Boston Alternative Energy Facility

Statement of Common Ground between Alternative Use Boston Projects Limited and the Environment Agency

Planning Inspectorate Reference Number: EN010095

Date: ~~December 2021~~ February 2022

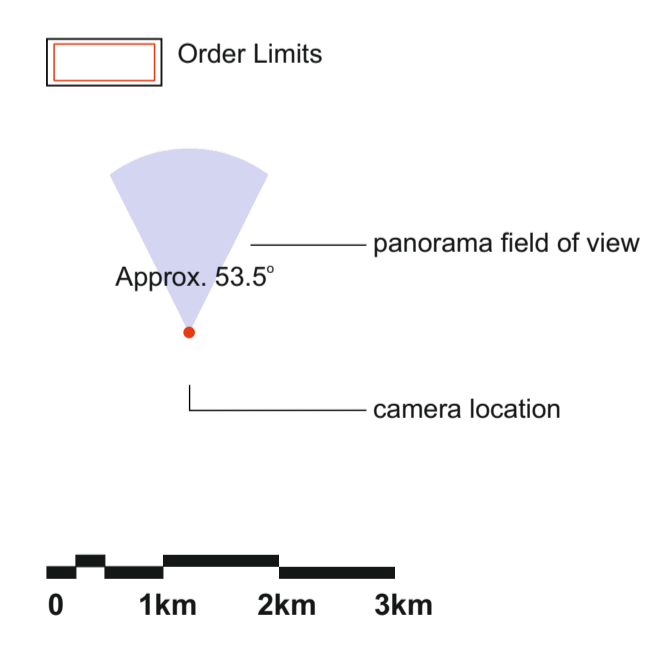
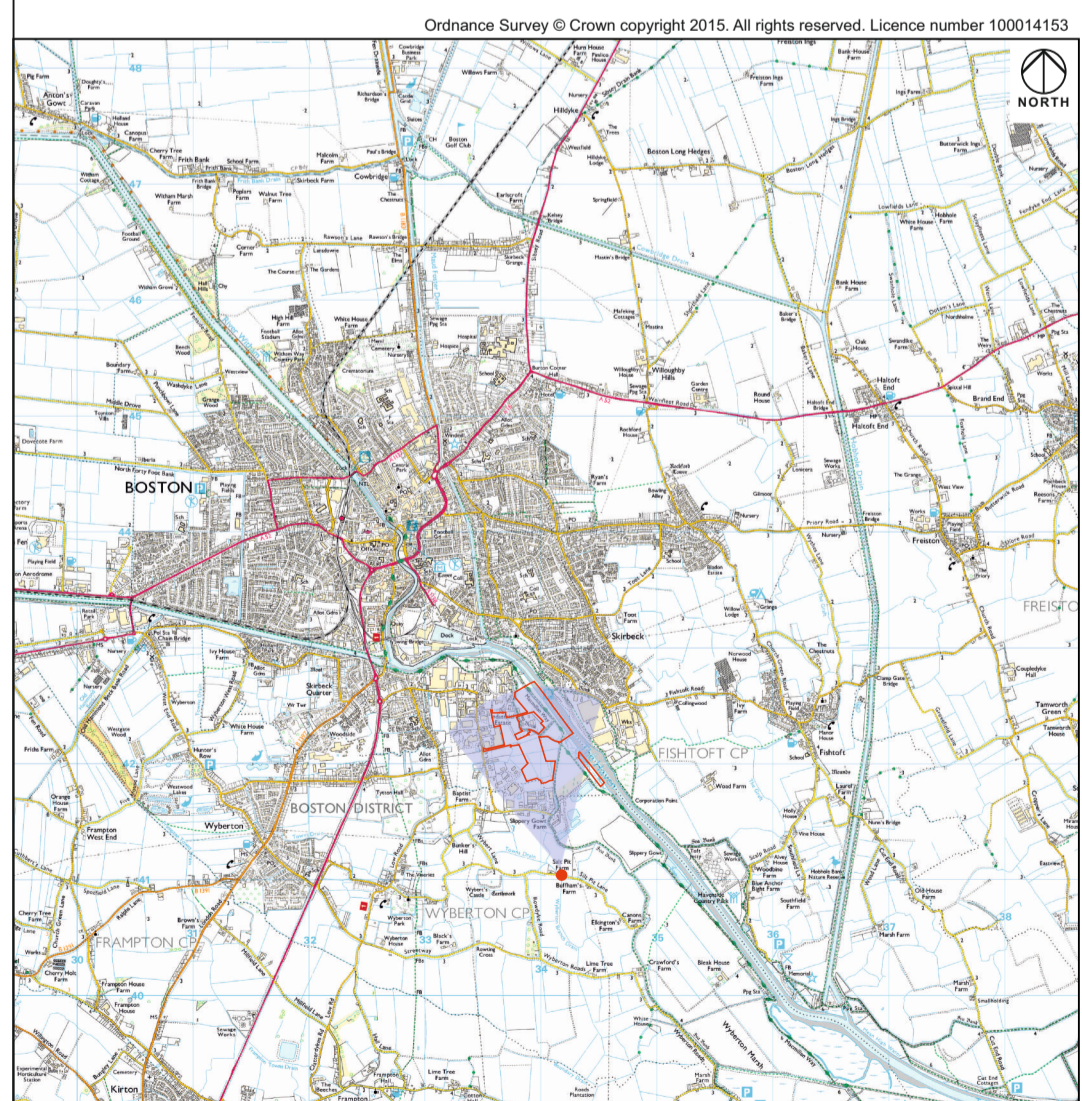
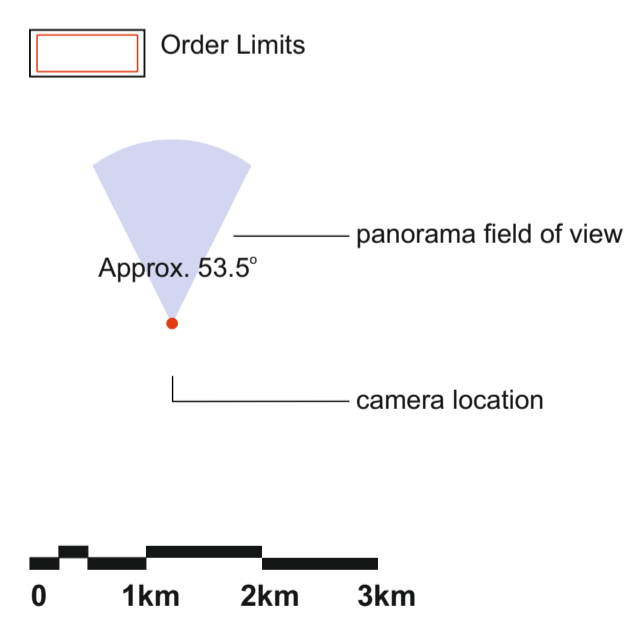
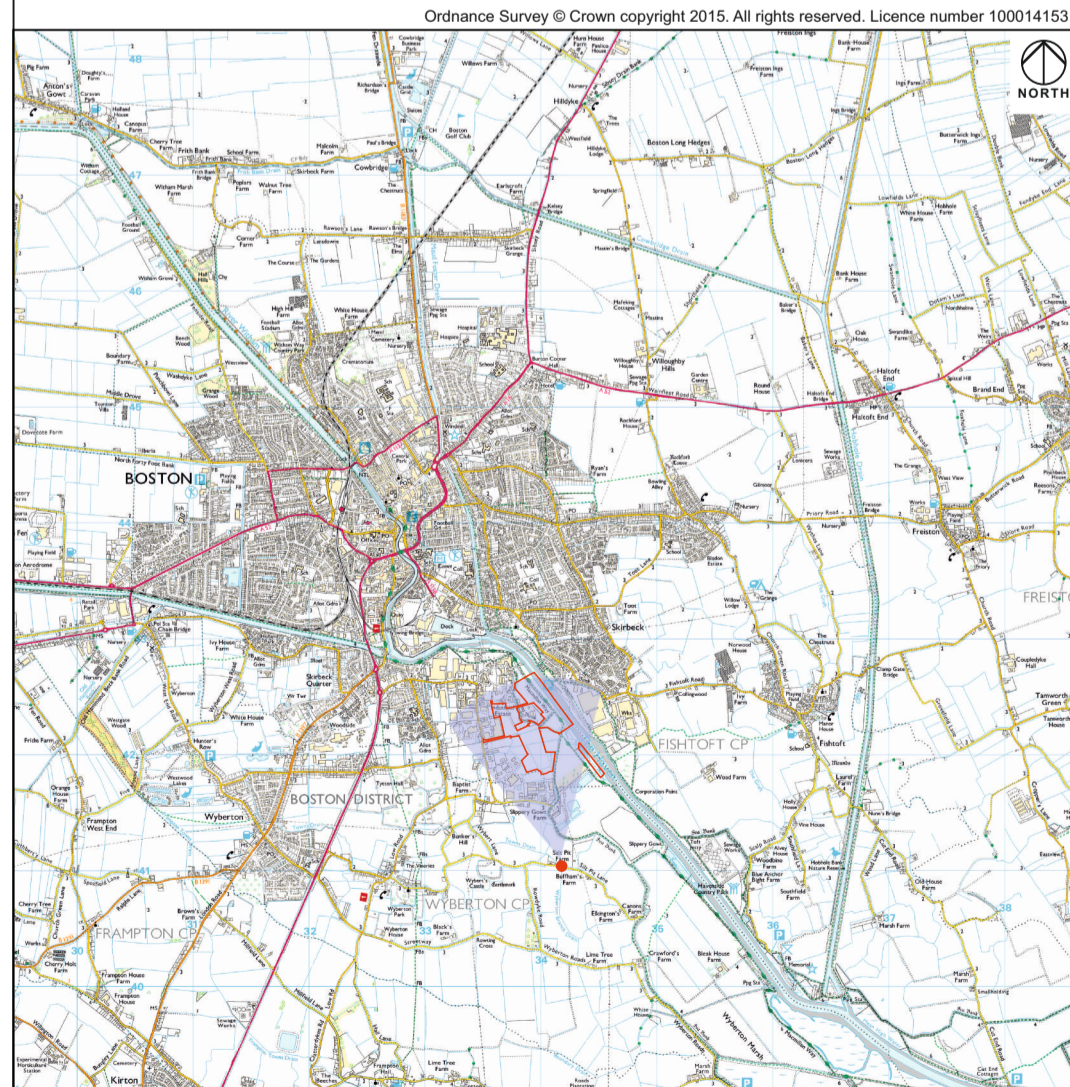
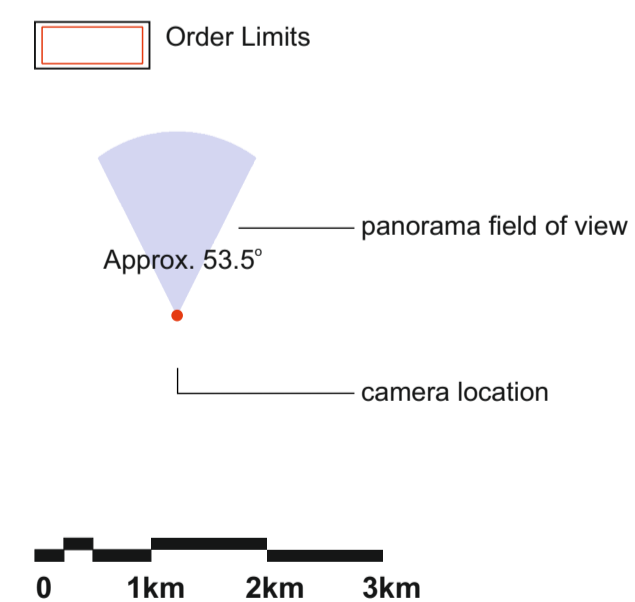
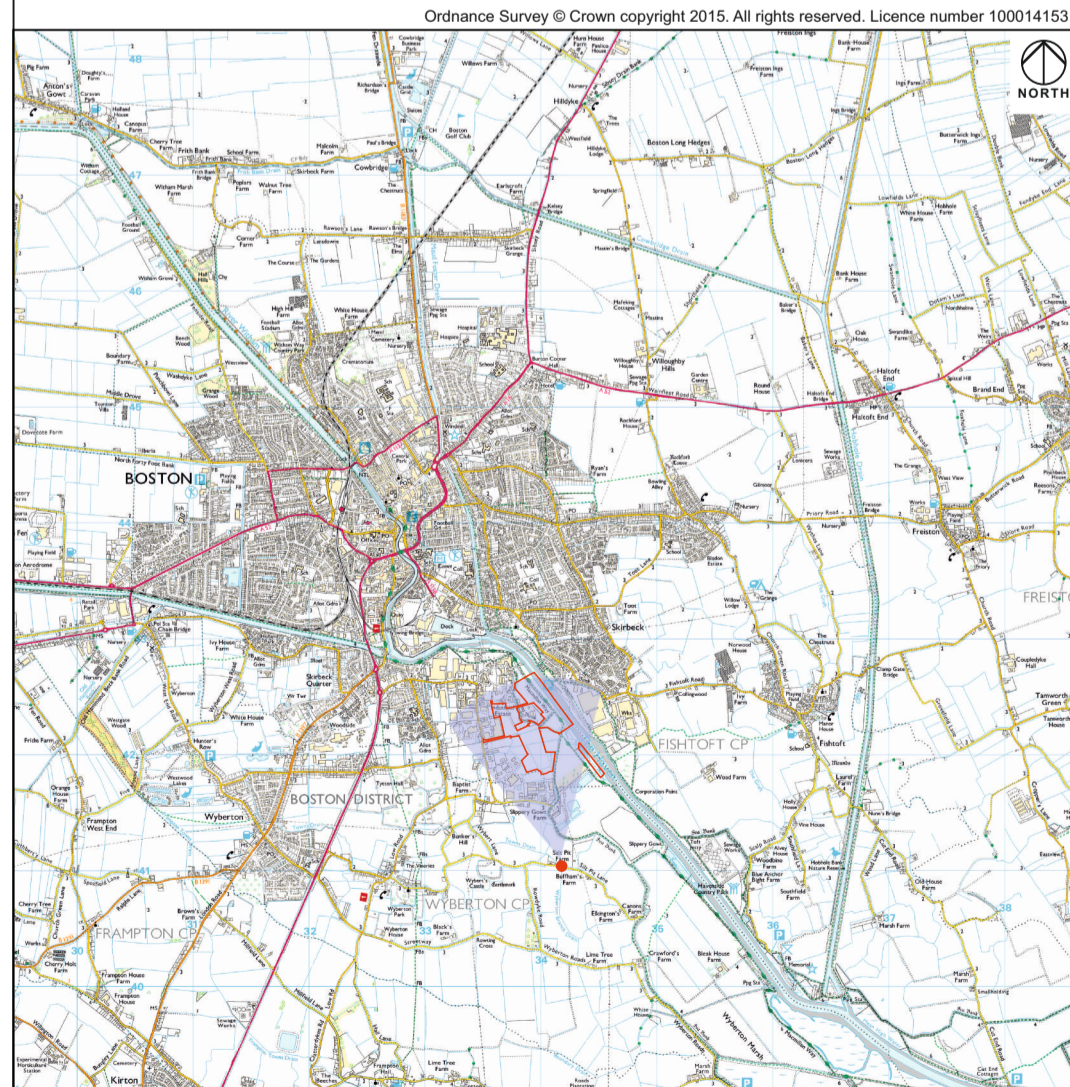
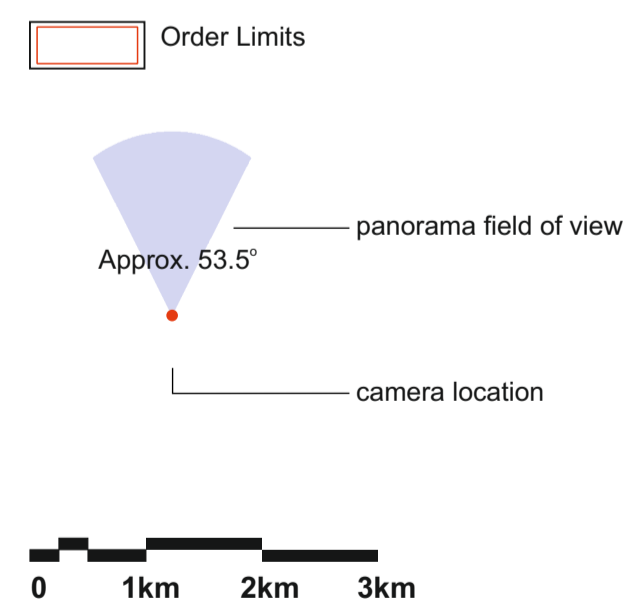
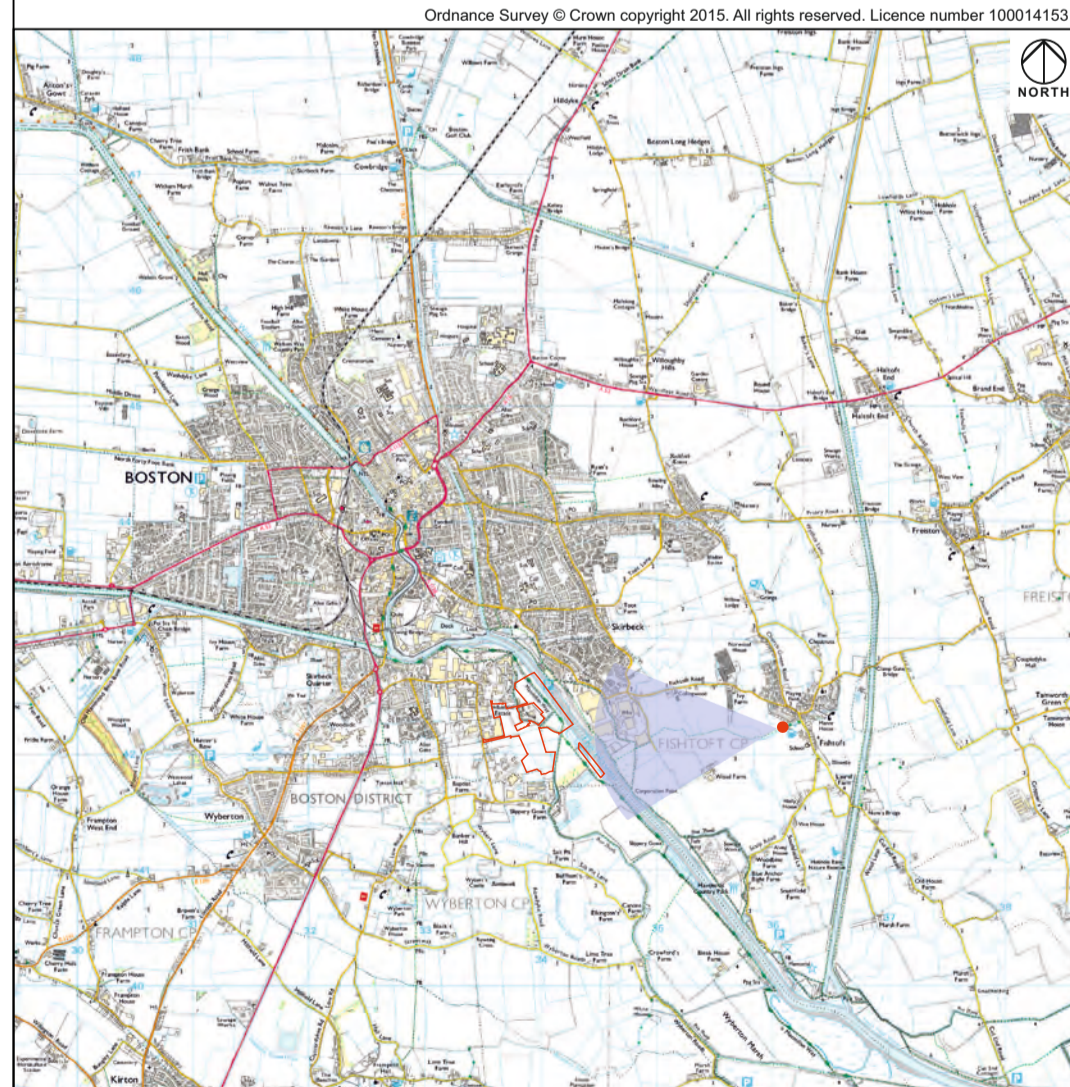
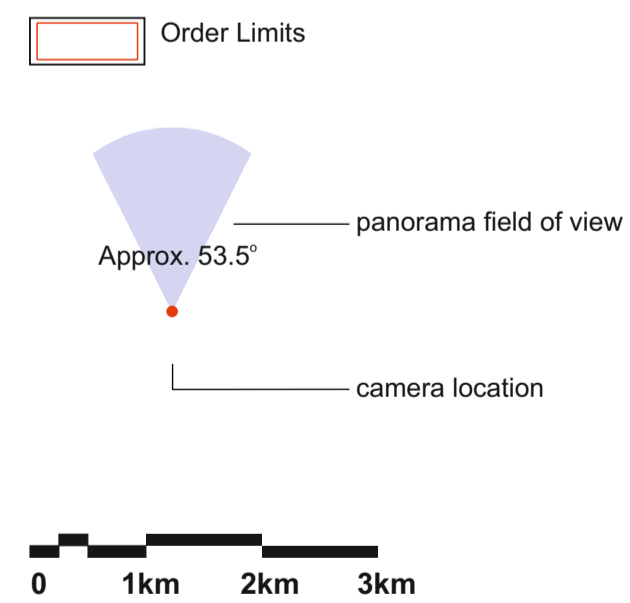
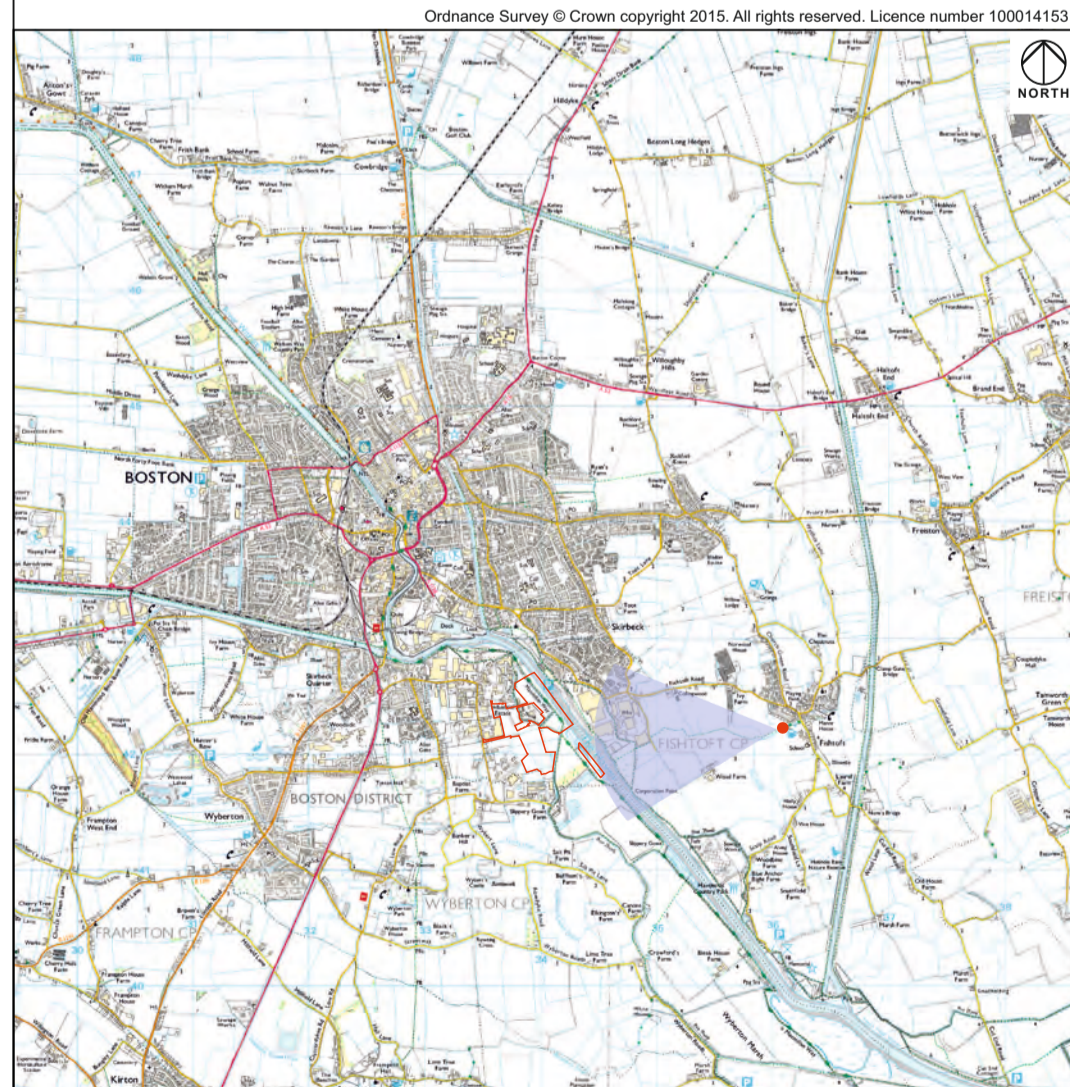
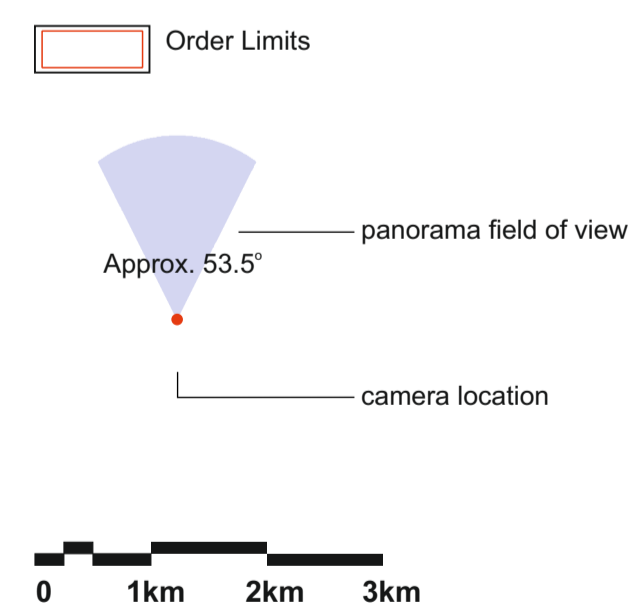
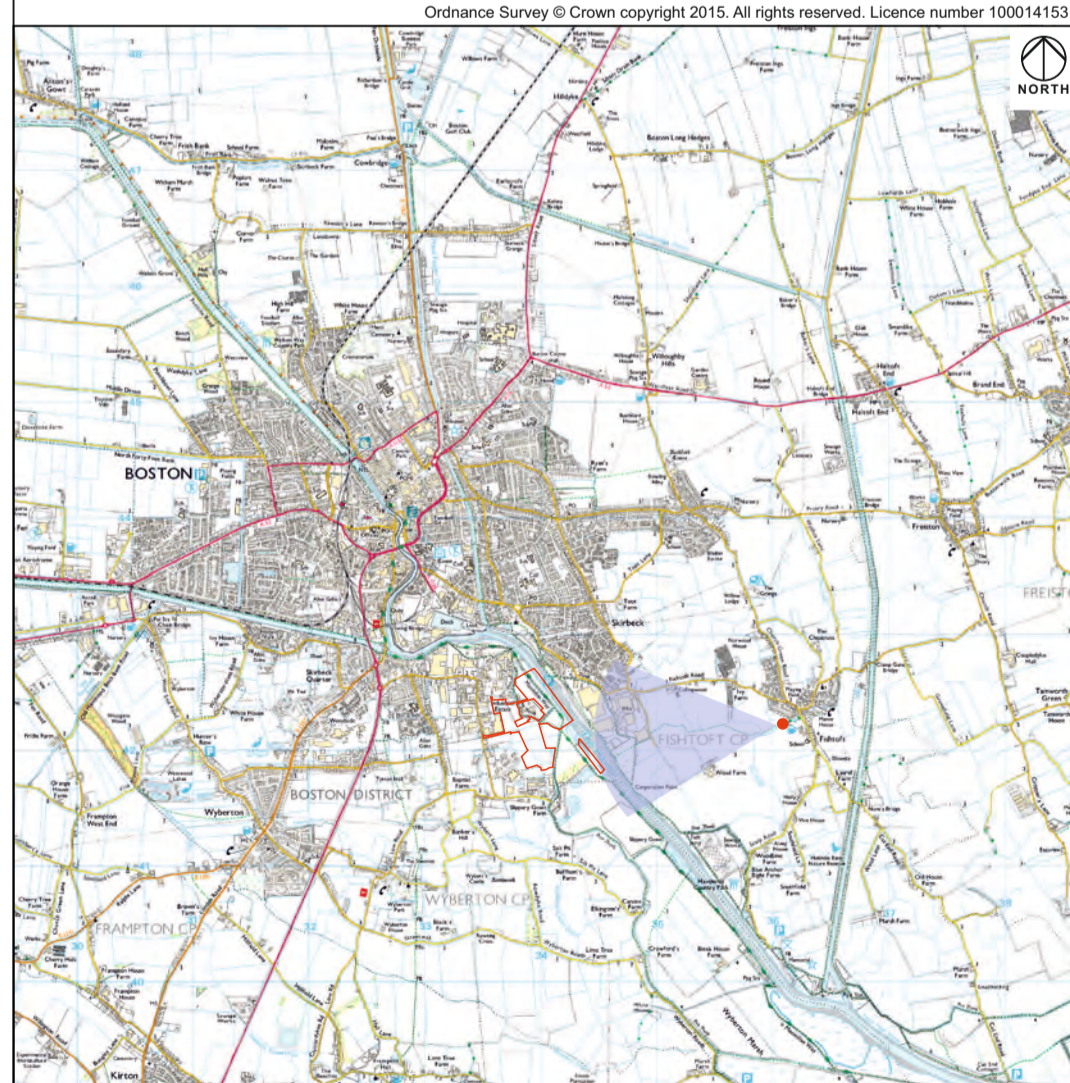
SoCG Reference	Document Reference	Topic	EA's Comment	AUBP Response	Status
EA 9.1	Chapter 9 Landscape and Visual Impact Assessment (document reference 6.2.9, APP-047)	Landscape and visual impact assessment	<p>The EA notes further information is needed on visible plumes.</p> <p>The EA notes a large visual impact on the landscape.</p> <p>The EA acknowledges that the information submitted is consistent with what it would expect to see from this type of process.</p>	<p>Further information on visible plumes was provided within documents submitted at Deadlines 1 and 2 including an updated Chapter 9 Landscape and Visual Impact Assessment (LVIA) (document reference 6.2.9(1), REP1-004) and Chapter 14 Air Quality (document reference 6.2.14, REP1-006) and updated photomontages (document reference 6.3.7(1), REP2-017 and document reference 6.3.9(1), REP2-019).</p> <p>The LVIA identifies significant, irreversible adverse visual effects upon certain visual receptors. Effects upon wider landscape character from visible plumes are lessened due to the existing baseline and presence of industrial and infrastructure features.</p>	Agreed
